Planning Application Ref: WA/95/18/RES

Location: Land east of Tye Lane, Walberton

Description of works: Approval of reserved matters following outline consent WA/44/17/OUT for the erection of 175 No. dwellings, car parking including garages, internal access roads, footpaths, parking & circulation areas, hard & soft landscaping, allotments, play areas/equipment & community orchard & other associated infrastructure & engineering works. This application may affect the character & appearance of the Walberton Village Conservation Area

Tree Officer / Parks and Greenspace Team

Tree Survey & Constraints with Shading

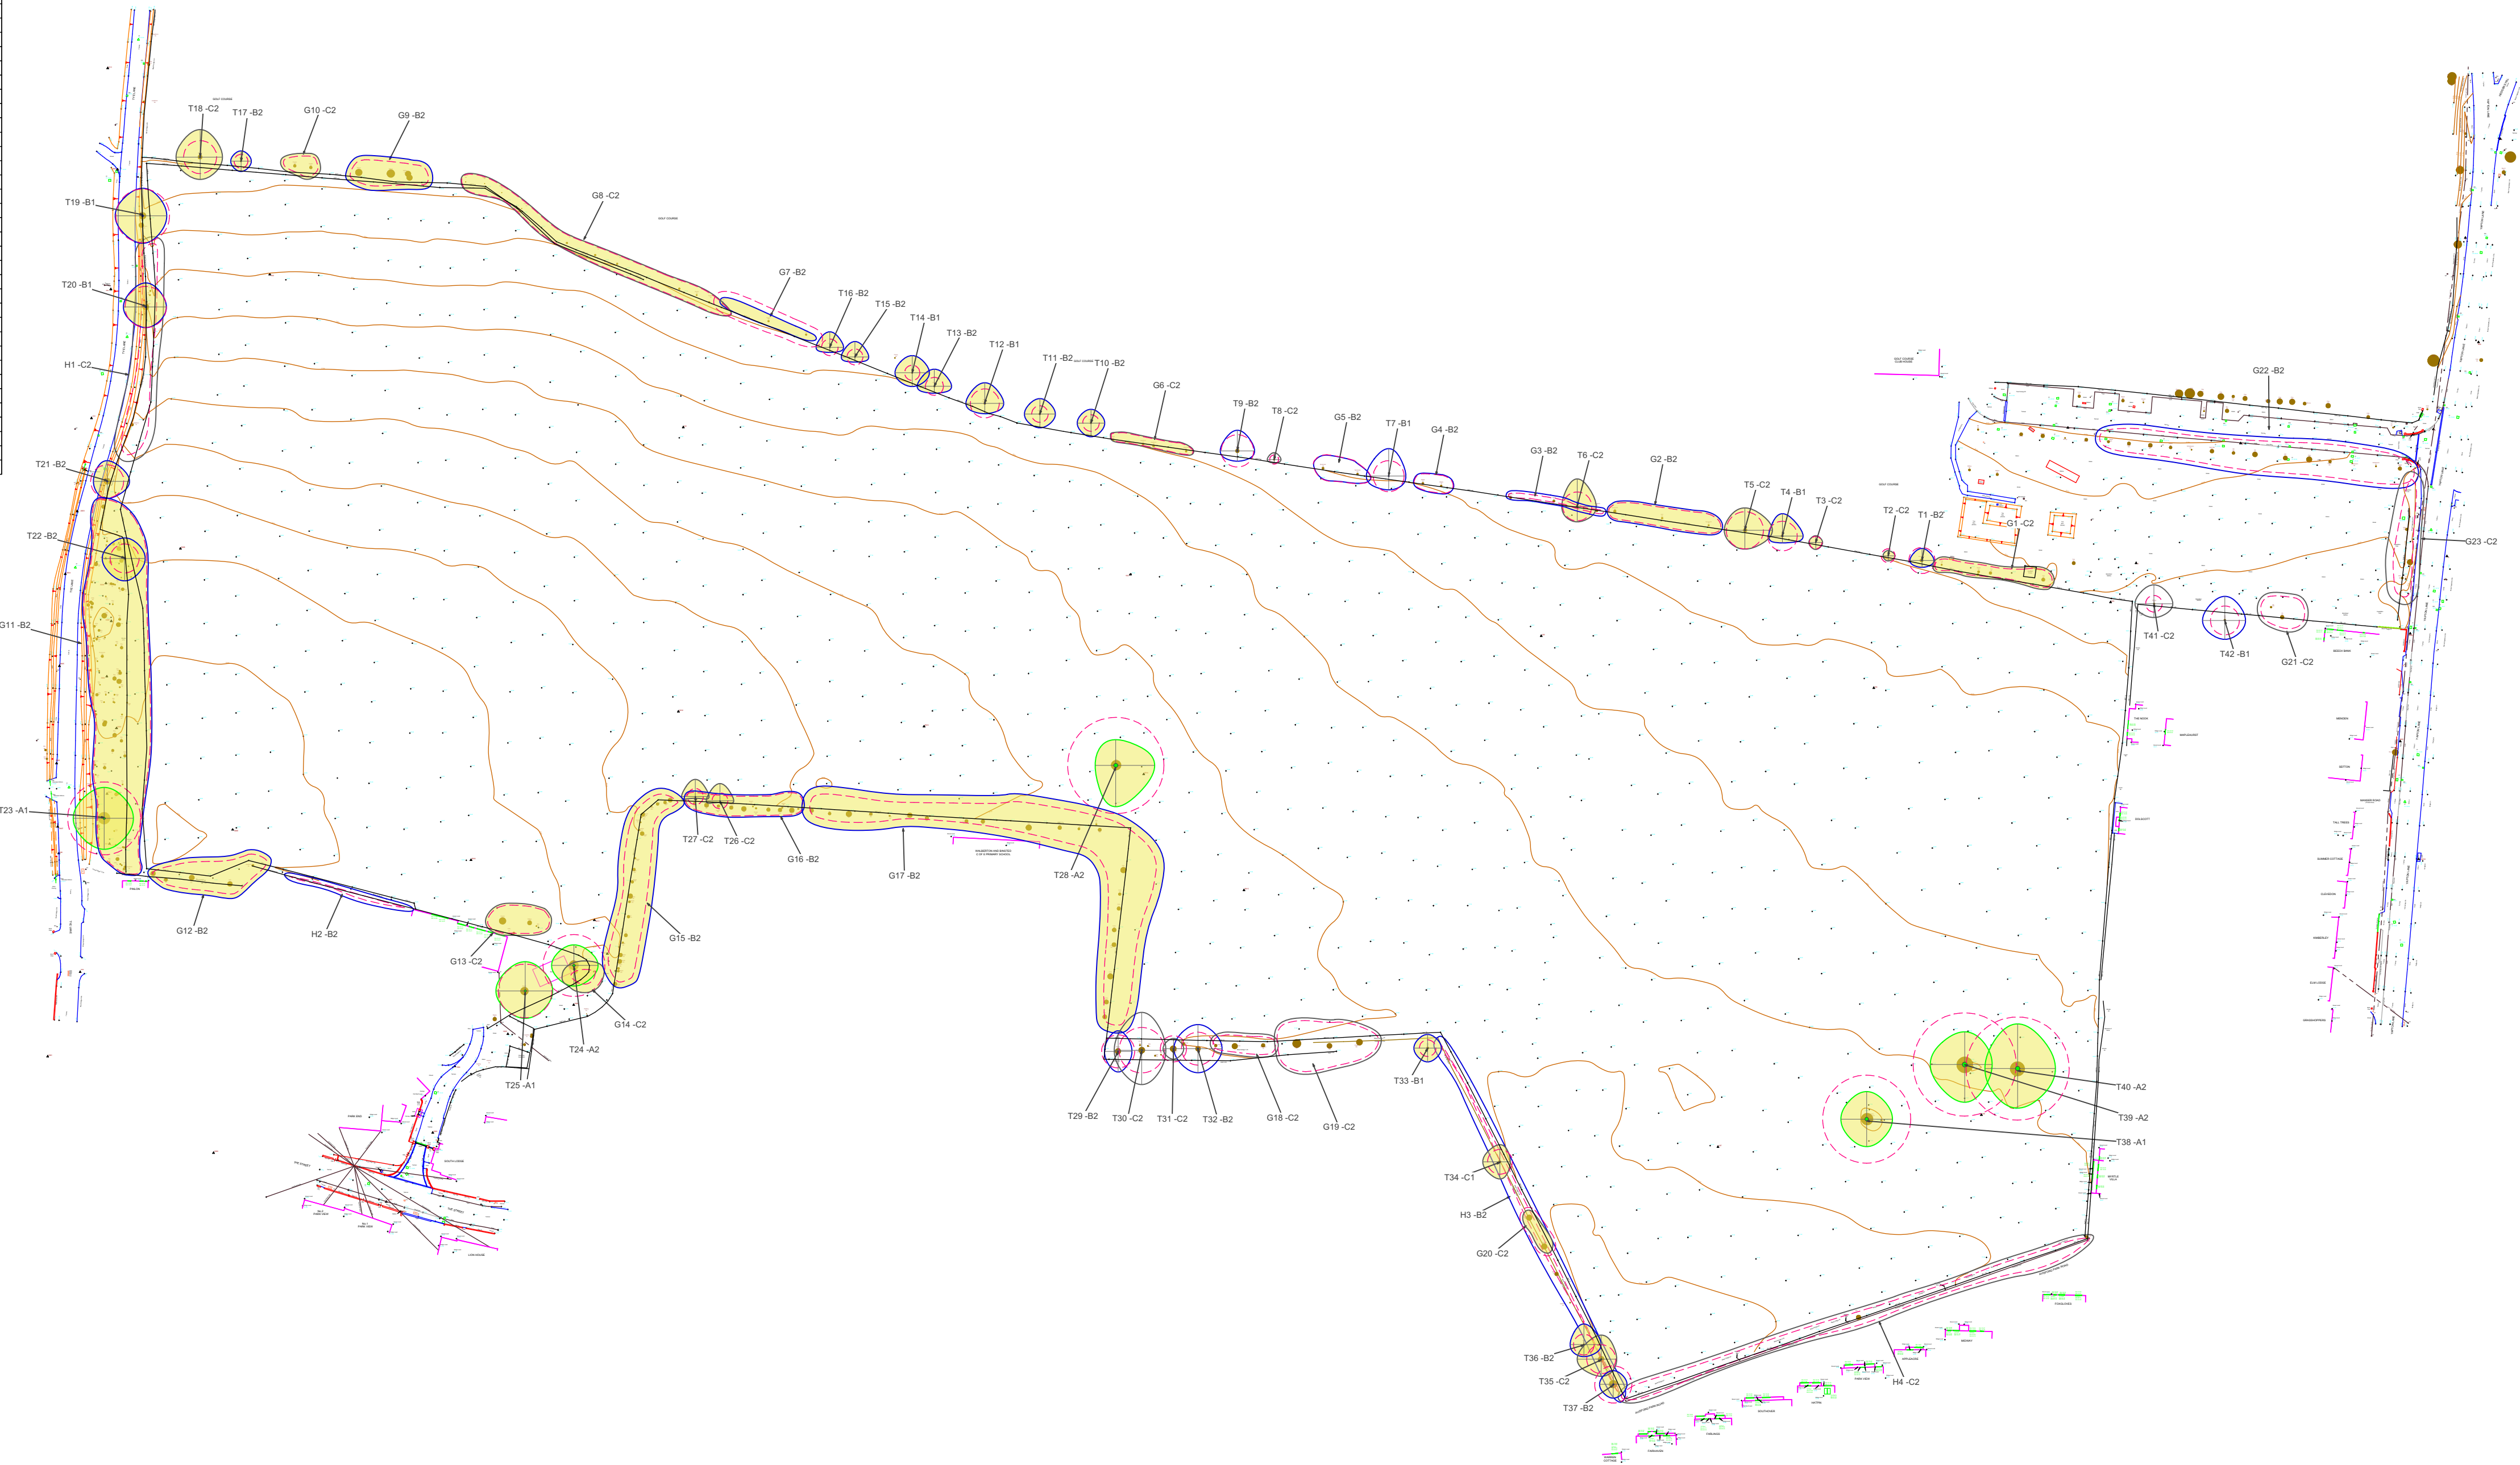
- The original objection must be sustained as the applicant does not appear to have fully addressed long-established concerns. RPA incursion from carriageway/driveway construction appears to persist at T28. This is unacceptable to me in isolation but especially so as the tree is going to be the recipient of cumulative (potential) stress events - namely the significant crown reduction pruning to bring it to an appropriate state for residential area, subterranean thrust-boring to install new pipework, construction tight to the west edge of the RPA and the aforementioned vehicle access.

- We have not yet had site of a detailed arboricultural method statement and tree protection plan which provides details of and demonstrates how the few significant trees deep within the site (T28, T38-T40) are to be adequately respected and protected.

- As it stands I must register an **OBJECTION**, until such time as I have sight of a definitive **site layout plan** which clearly shows the following; tree root protection areas, details of all RPA incursions (e.g. footpath, carriageway, pipework run), together with an associated **tree protection plan** showing any areas of 'No-dig' construction and a supporting **method statement (AMS)** which explicitly describes all the measures to be taken to ensure those trees are adequately respected and protected.
